Neil Crowther, Esq
Arundel District Council Planning
Maltravers Road
Littlehampton BN17 5LF.

I have a few questions regarding
Planning WA/114/18/HH.

Proposed East Elevation

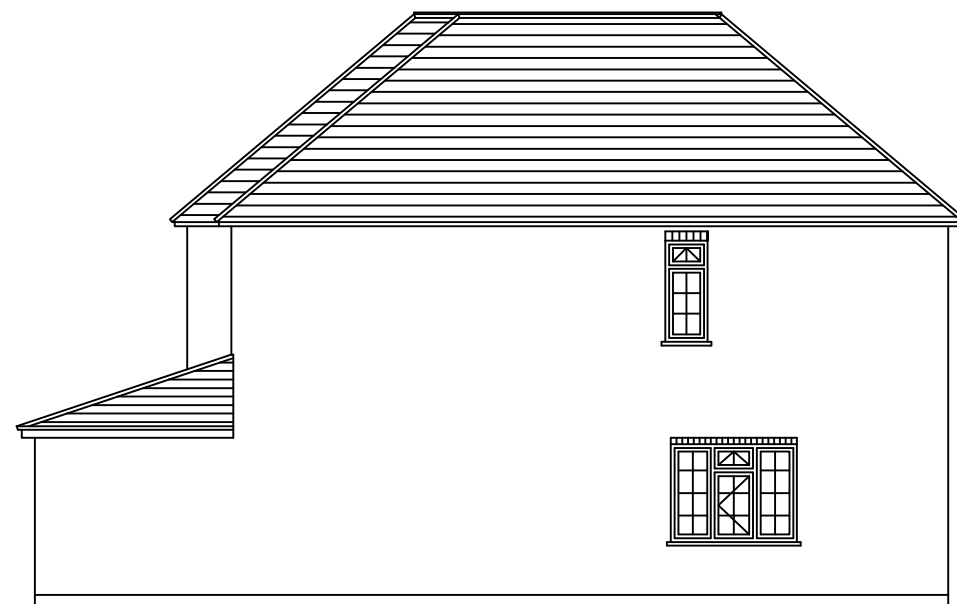
- 1) On a previous application - Eastern Elevation - the proposed ground floor window was deemed obtrusive as it would be only 4ft away overlooking my side entrance. Only the small 1st floor frosted window was allowed.
- 2) South Elevation: building out to enclose the porch thus they are 5ft beyond the Building Line!
- 3) Garage - Storage: this would be further south of any building in Arundel Road 15ft beyond the Building Line with the Garage opening onto my property. The private road alongside their property is for my Wine Shop Customers not for their extended use.
